Response to 'Response to Observations Received Ballivor Wind Farm (ABP Ref. 316212)'

On behalf of DRB Community Company Limited by Guarantee

By Jesmond Harding

Site Layout Plan
Sheet 4 of 6

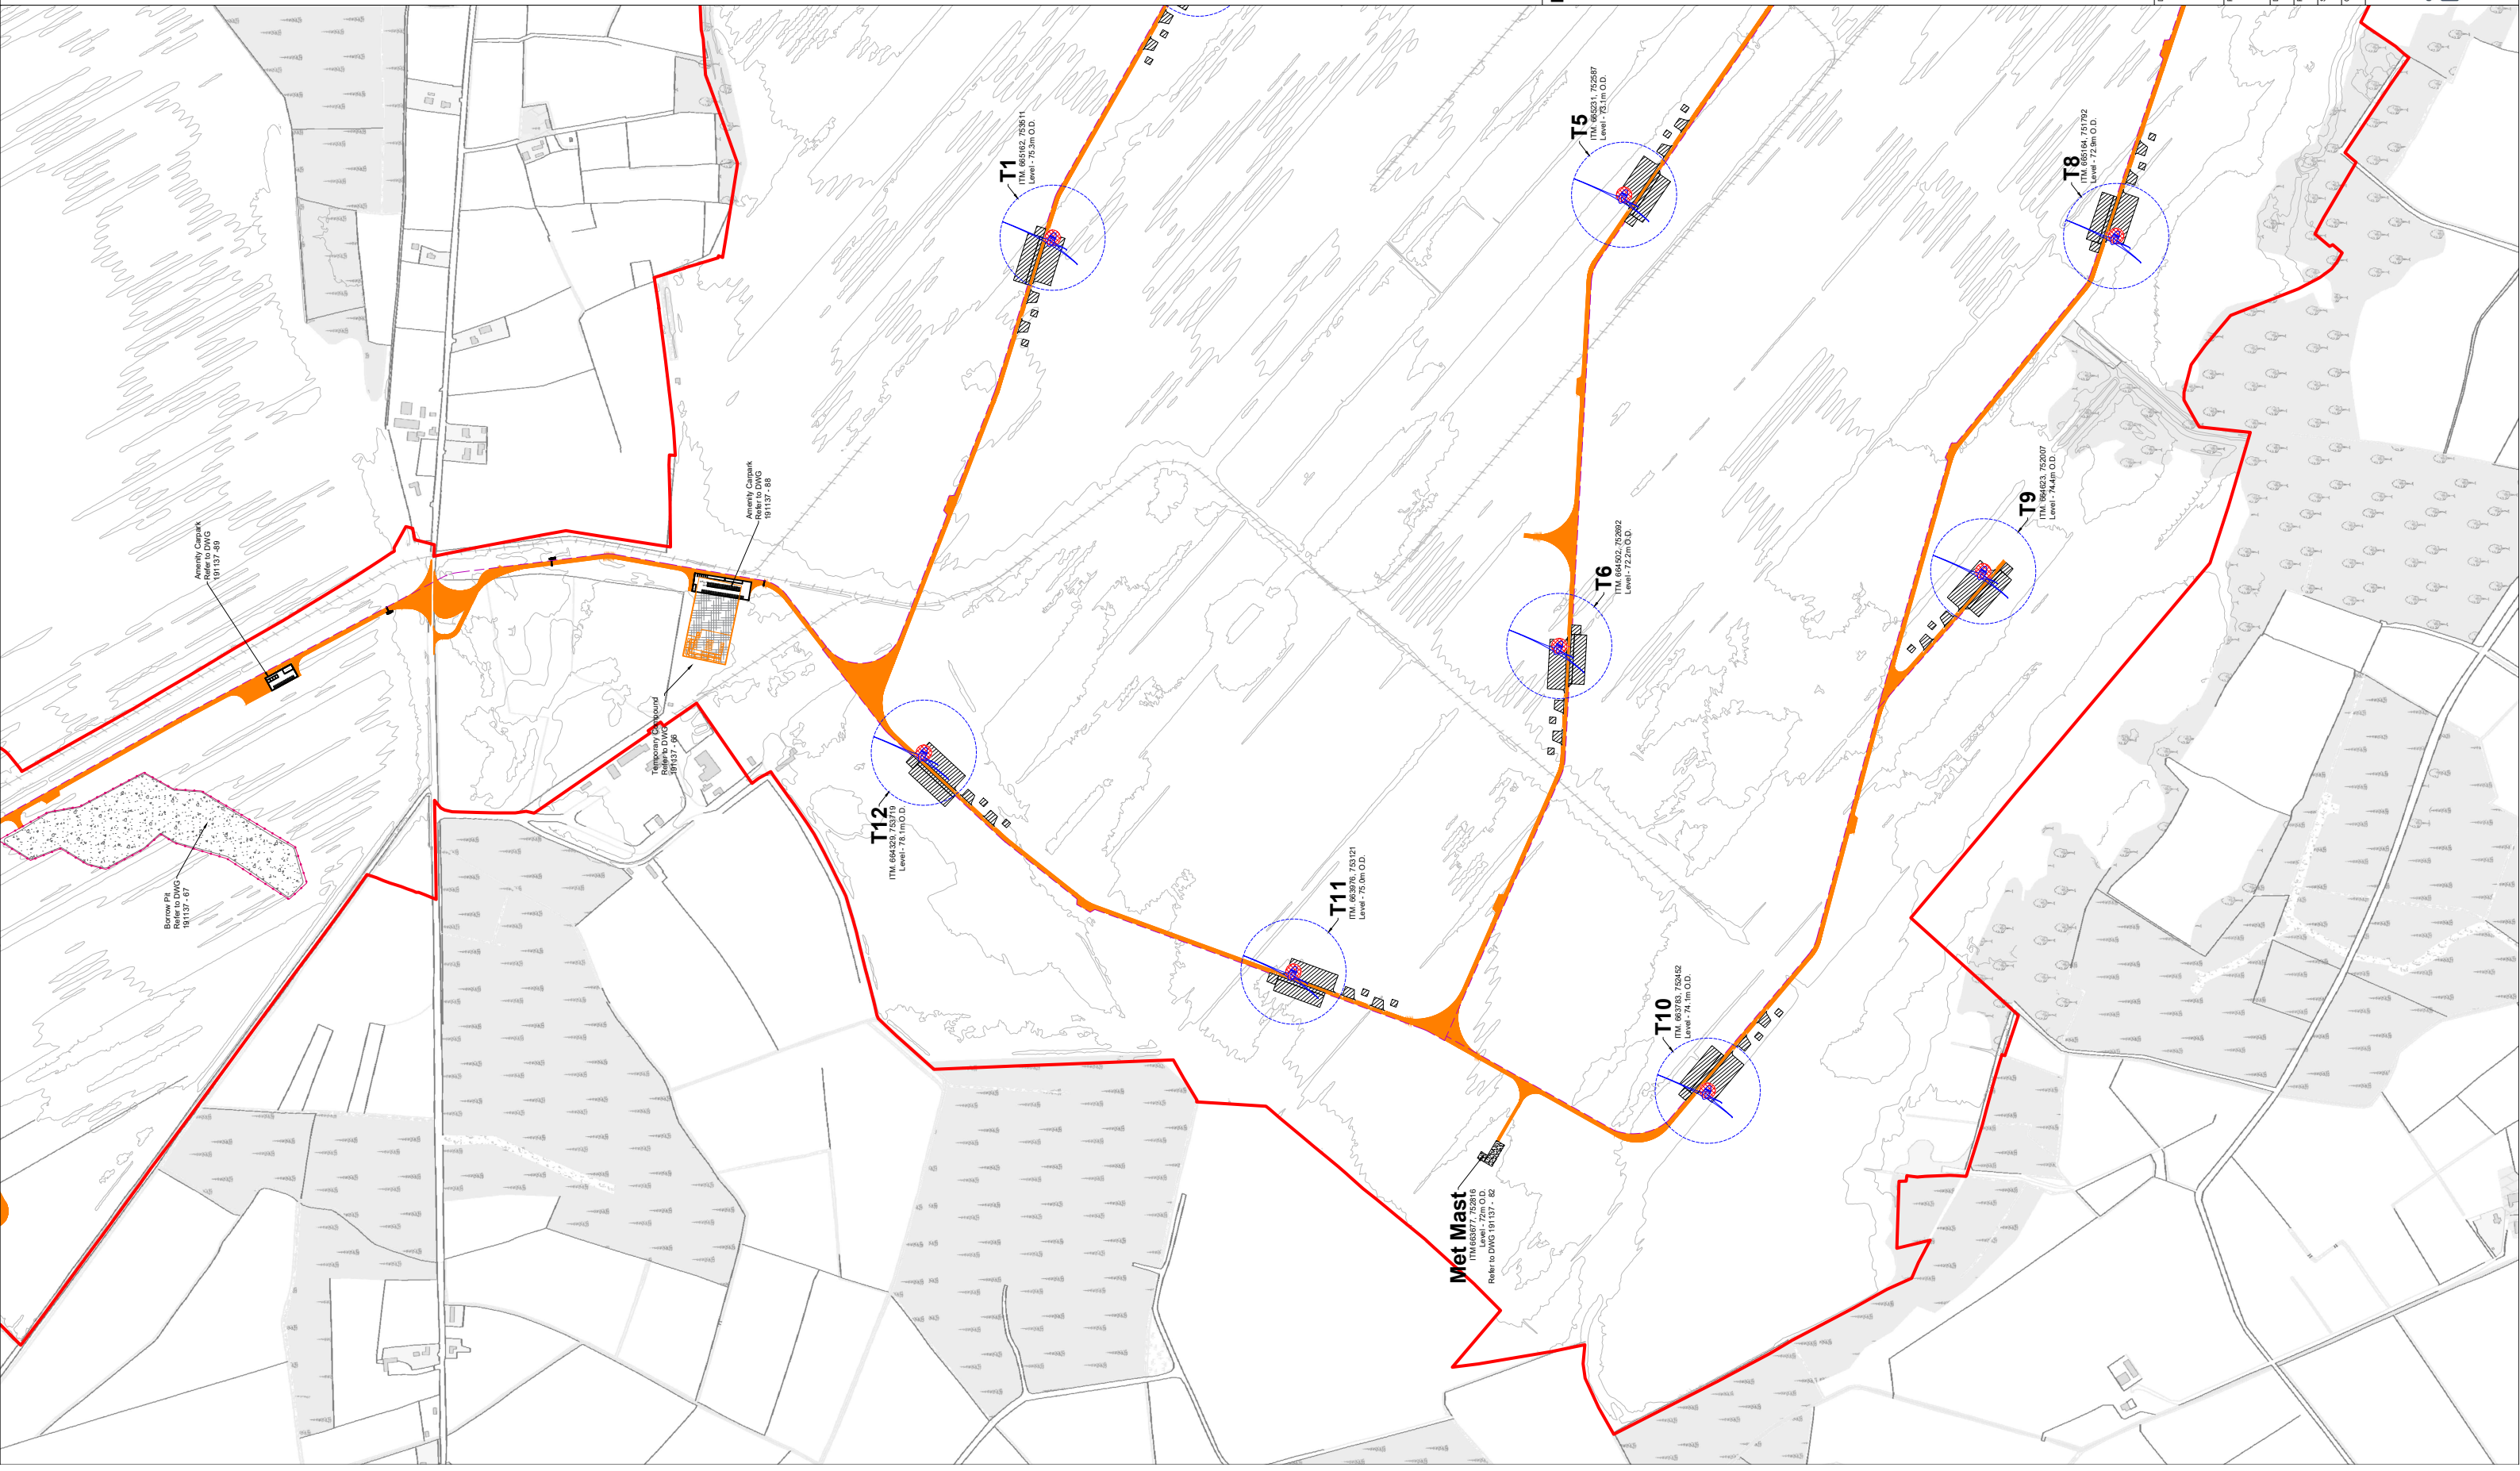
The Marsh Fritillary Impact Assessment does not address under mitigation the changes to the habitat that will occur when the road is constructed and cabling for the proposed turbines 13 and 14 is installed. It is likely that the drainage applied in advance of installing cables will reduce soil moisture which will stress the shallow-rooted foodplant of the Marsh Fritillary butterfly during extended dry weather which will impact foodplant quality. This can result in the starvation of the larvae. The warmer, drier summers expected will increase the danger of population loss. It should be noted that the breeding habitat in much of the proposed development site is on elevated ground and additional drainage will increase the stress on the habitat.

It is my expert opinion that the applicant's impact assessment on Ireland's only legally protected insect (the Marsh Fritillary) is insufficient; the available evidence suggests habitat elimination, specifically in the areas of planned turbines 13 & 14 and the potential for drying out of the remaining habitat.
